DRB Application No.: 08DRB-70068	Project # 1003798
Project Name: EMIL MANN ADDITION	
Agent: GREATER ALBUQUERQUE HOUSING PARTNERSHIP	Phone No.:

**CITY OF ALBUQUERQUE
PLANNING DEPARTMENT
December 19, 2007
DRB Comments**

RE: Lots 7-12, Block 27, Emil Mann Addition (Approved as Lots 1-14, Trumbull Village)

CITY OF ALBUQUERQUE
 PLANNING DEPARTMENT
 DEVELOPMENT REVIEW BOARD

15 10 5 0 10 20 30
SCALE: 1" = 30'
PROJECT NO. 0612PB03
DRAWN BY PGB
ZONE ATLAS: L-19-Z
27EMIL.CRS

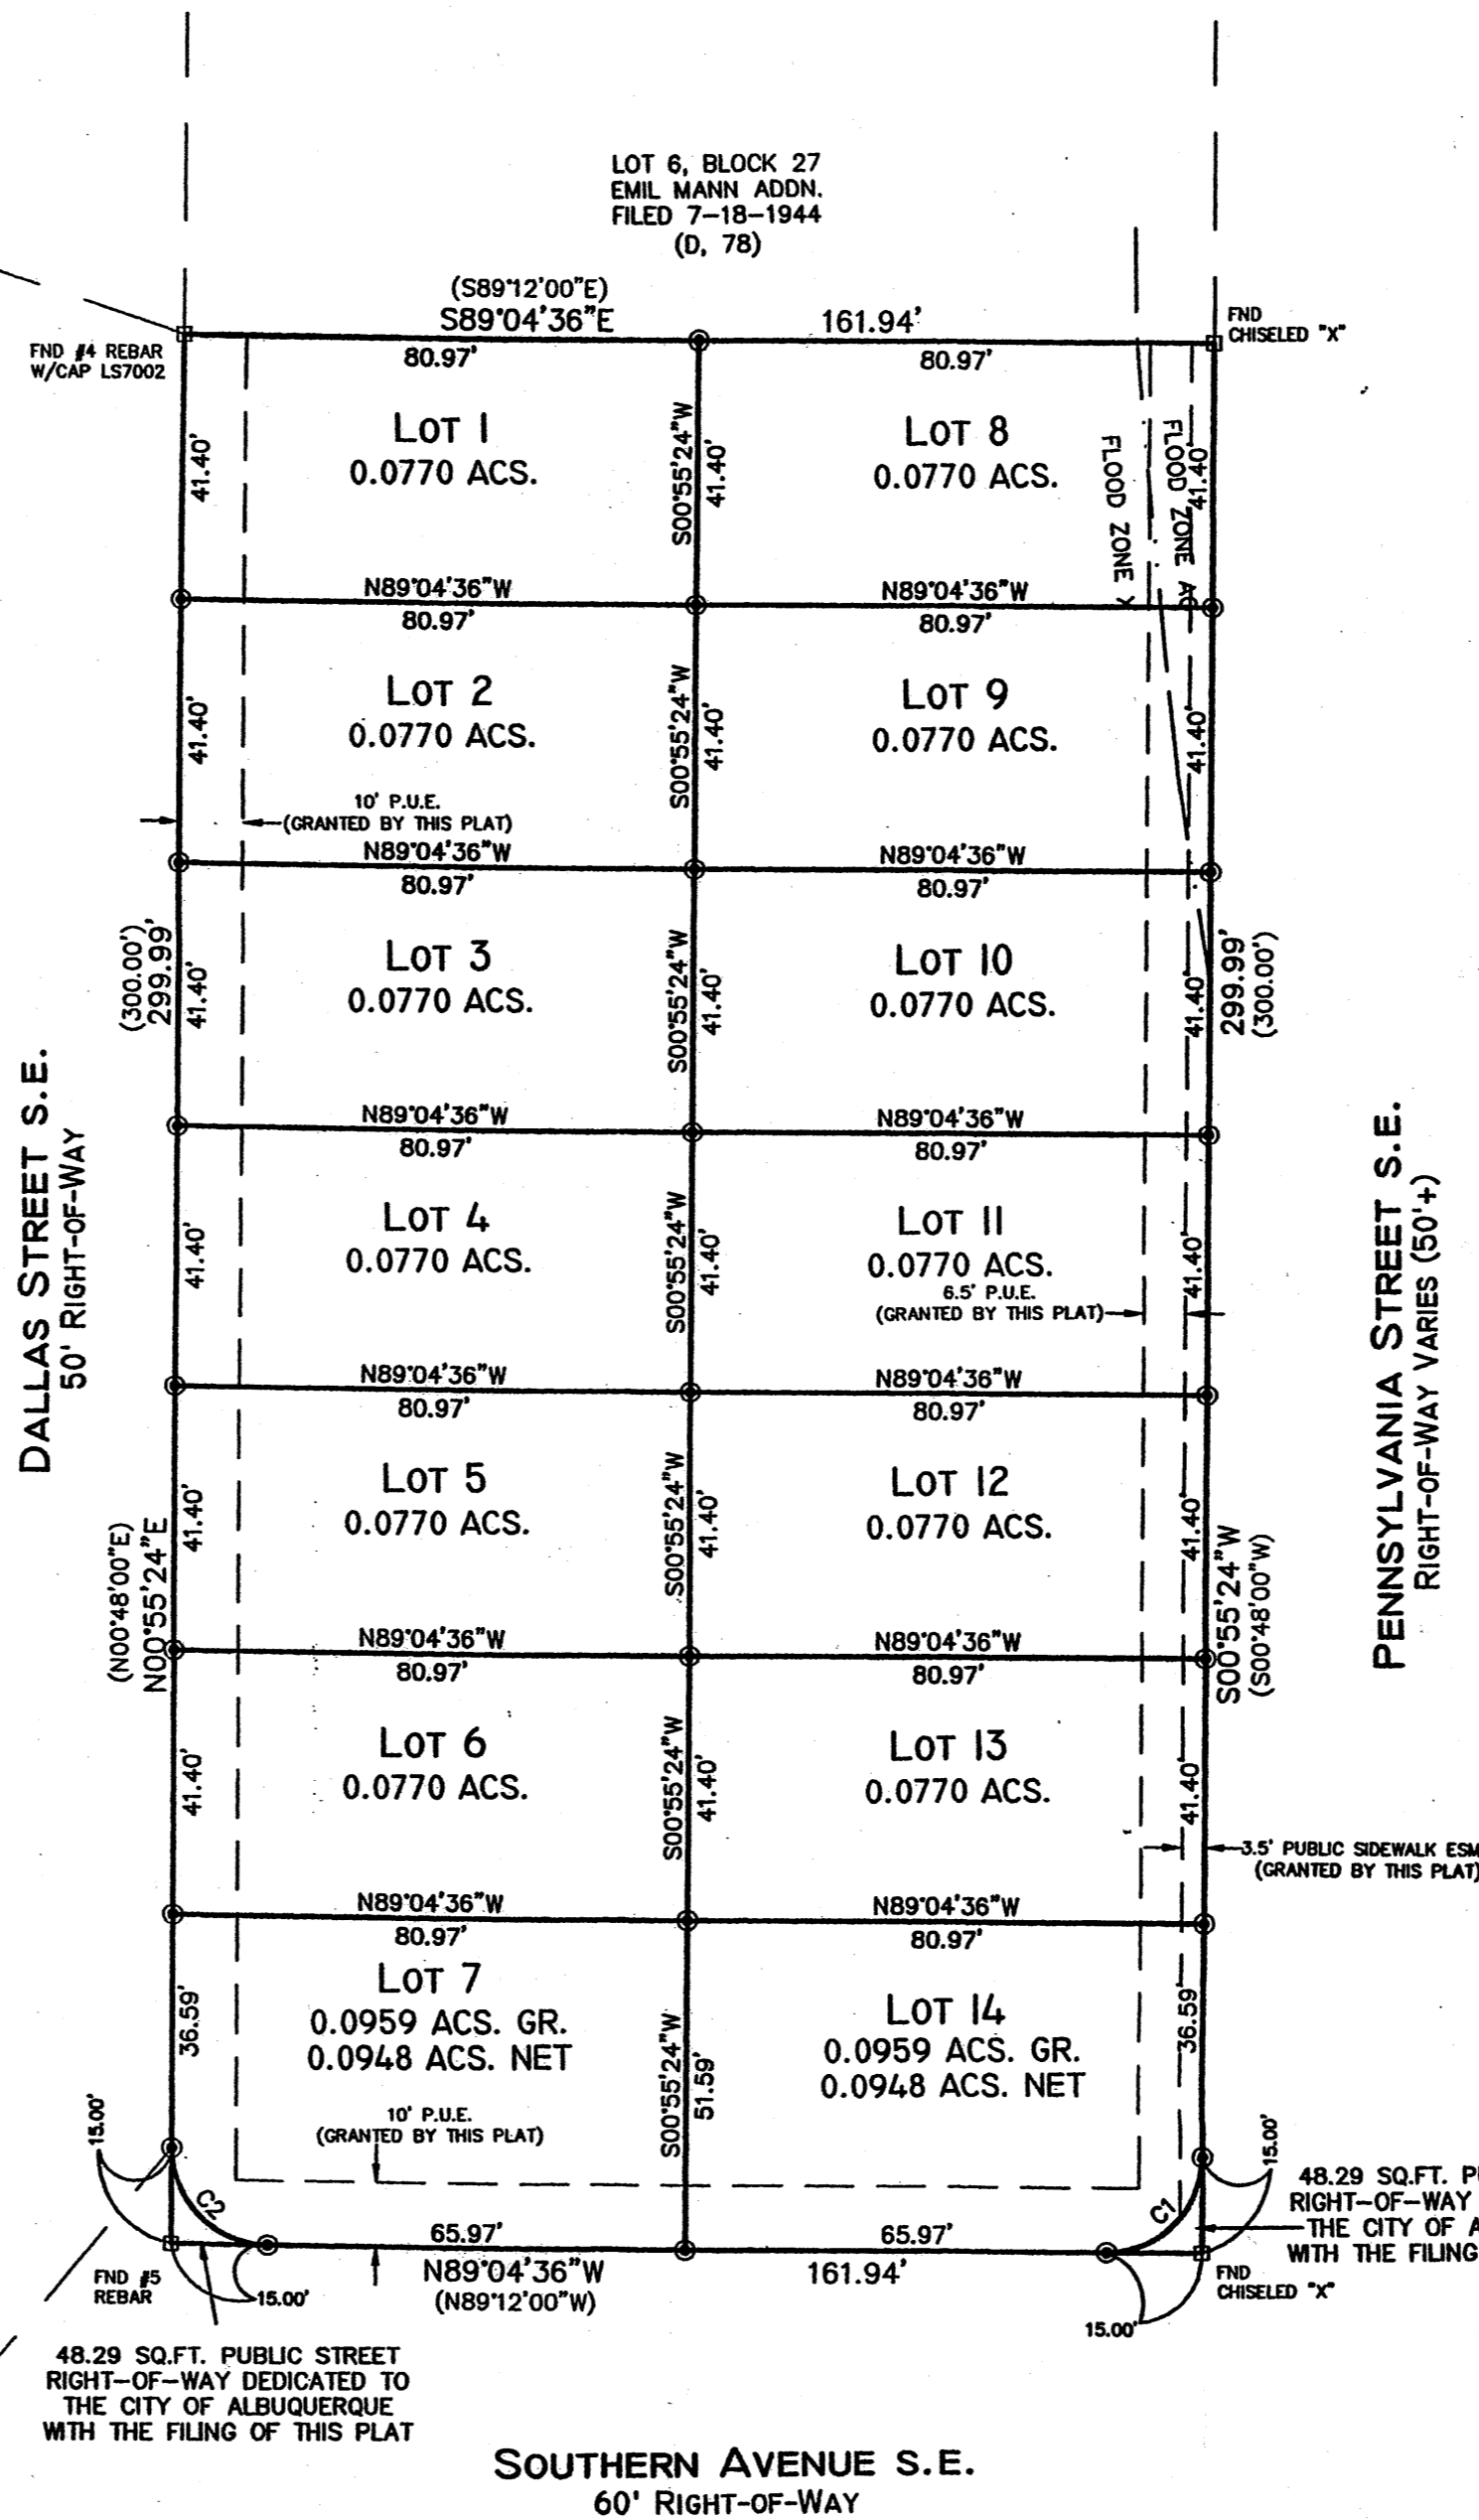
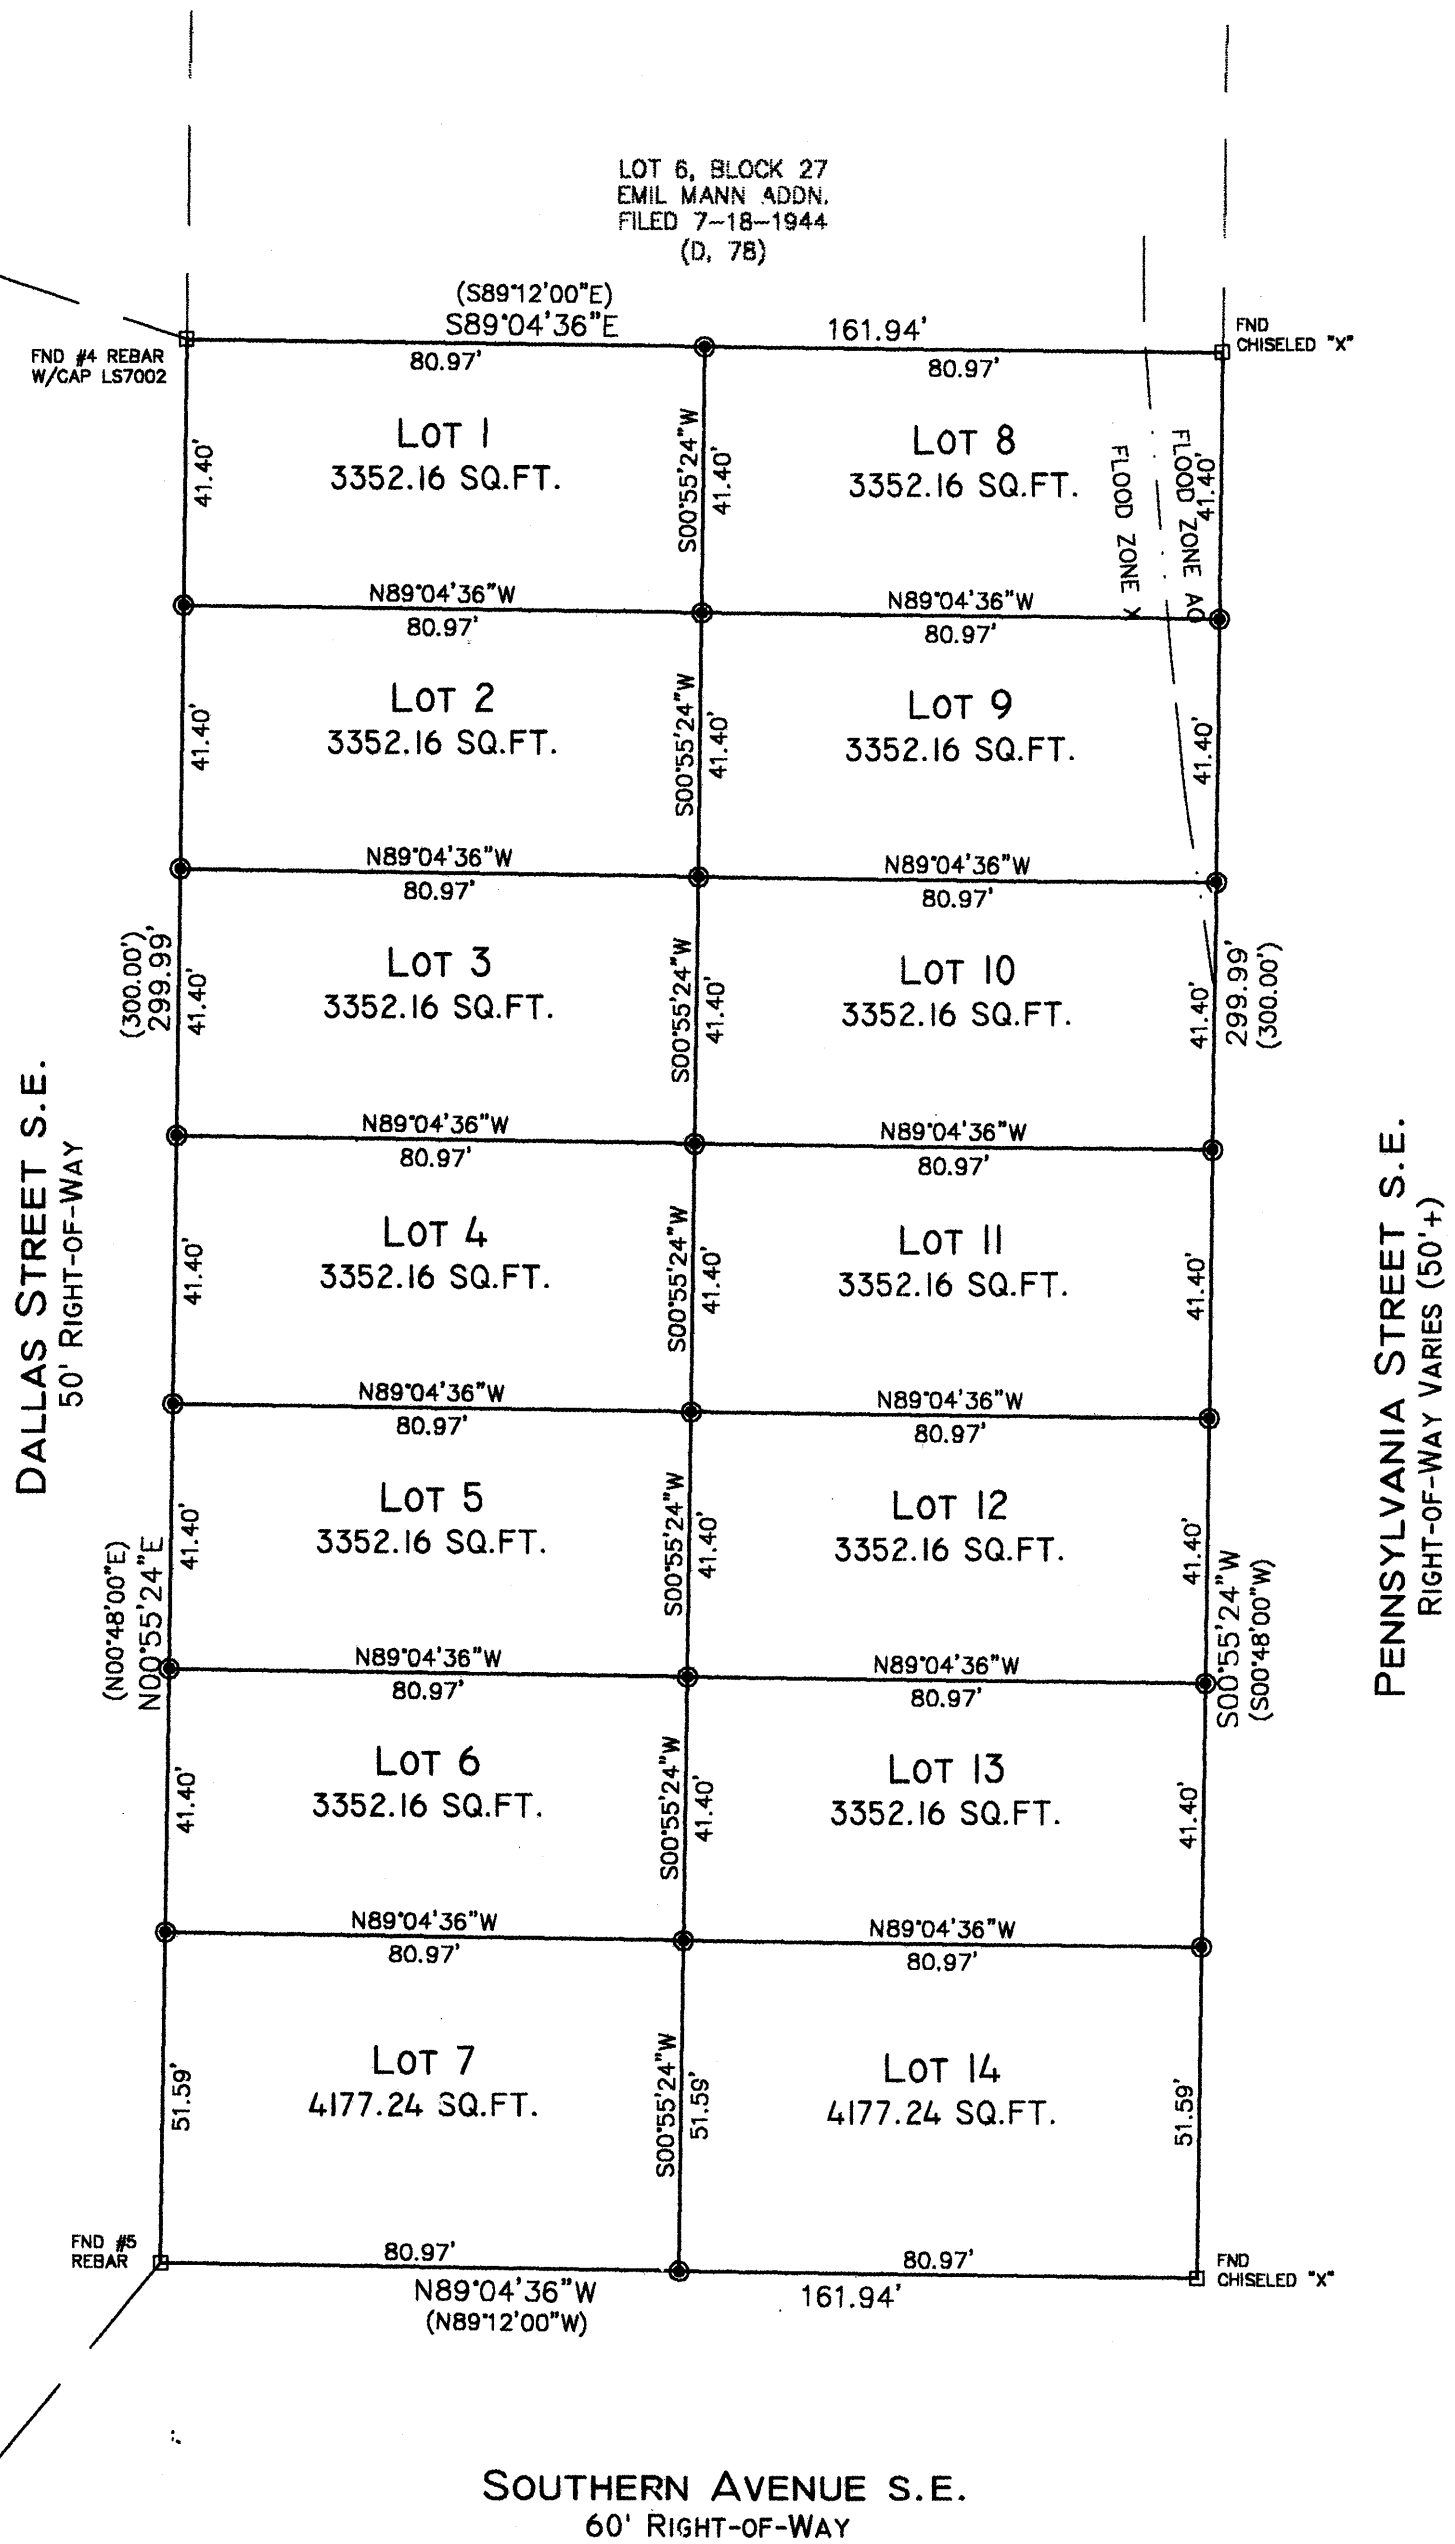
Radii dedication at Southern & Pennsylvania and Southern & Dallas is required.

Sidewalk easements along Pennsylvania are required.

✓ PNM Electric & Gas Preliminary Plat approval: **NOT APPROVED, NO PROVISION FOR EXISTING PNM OVERHEAD LINE AND NEW GAS AND ELECTRIC EASEMENT.**

Where are the radii dedications? The drive pad configuration will require sidewalks easements. What is the distance from face of curb to the property line? How big will the service cuts be? Typically, the City requires paving to avoid having numerous pavement cuts. If the property is zoned SU-1, where are the EPC findings and conditions?

GRADING PLAN
SCALE: 1" = 20'

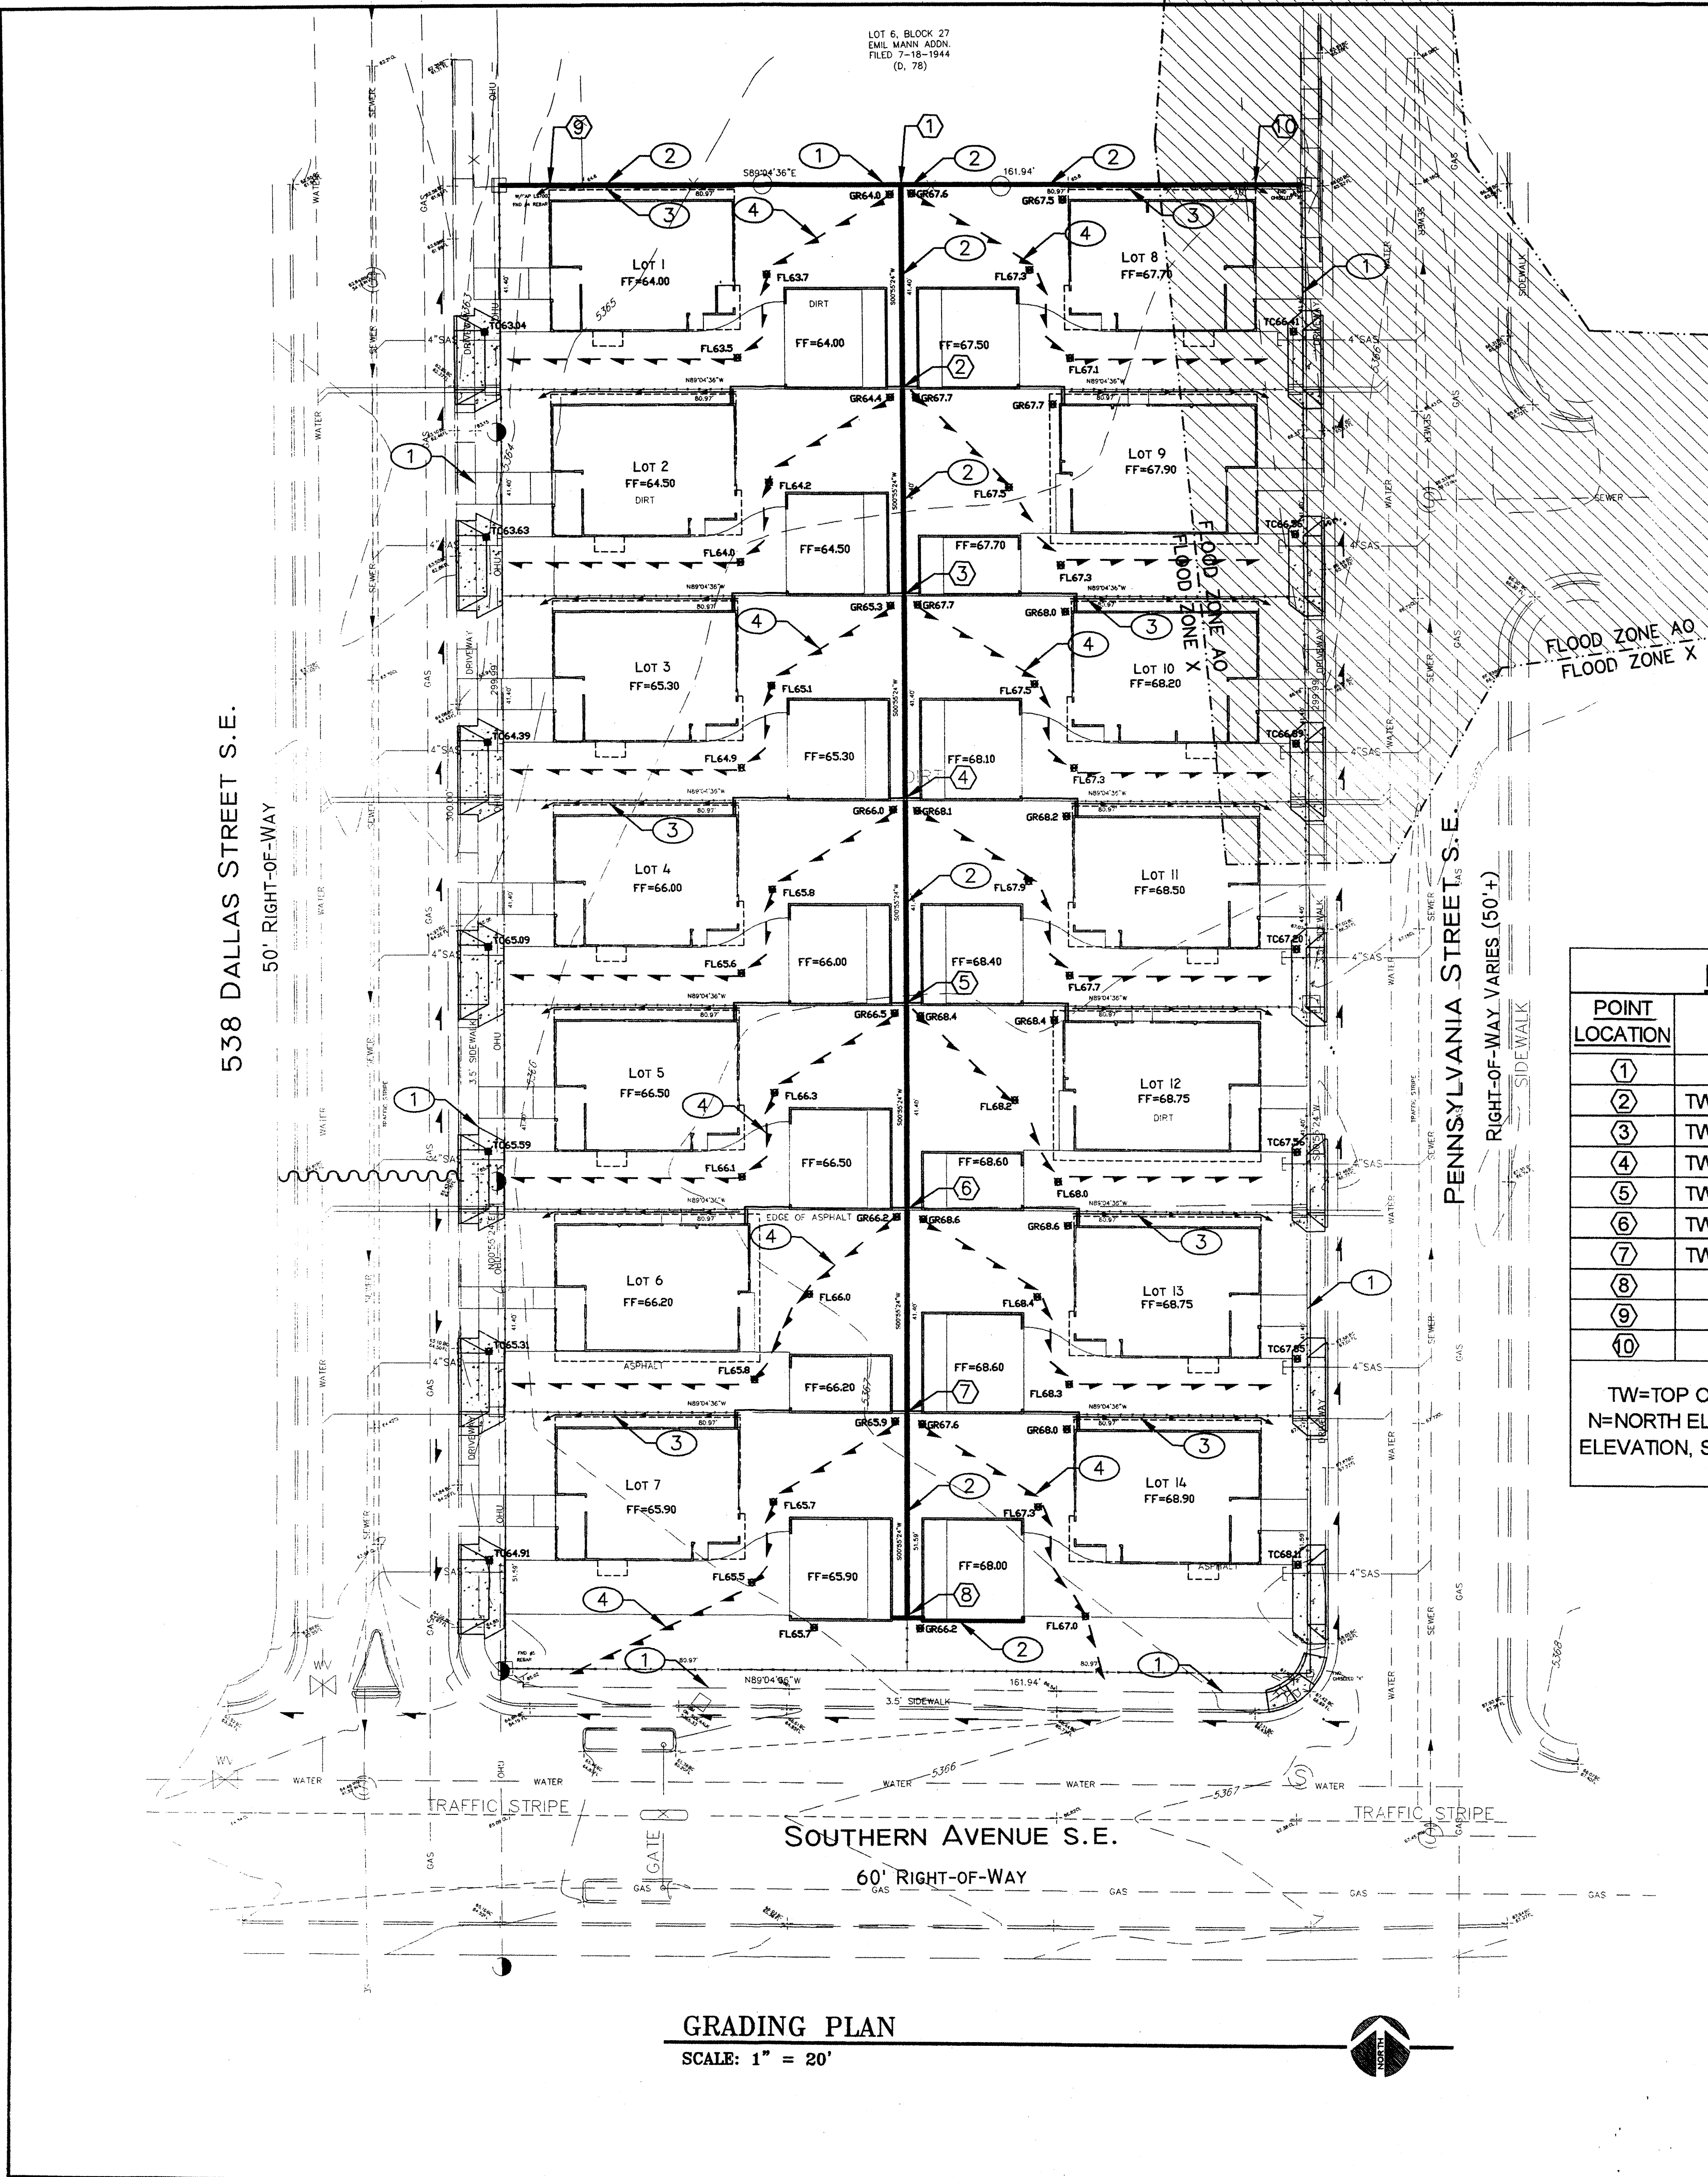
An approved grading and drainage plan dated 12-18-06 is on file for Preliminary Plat approval.

Need to add street paving to infrastructure list because of all the utility cuts. Engineer must verify that sewer services in Dallas can clear the 60" interceptor not shown on the Grading Plan.
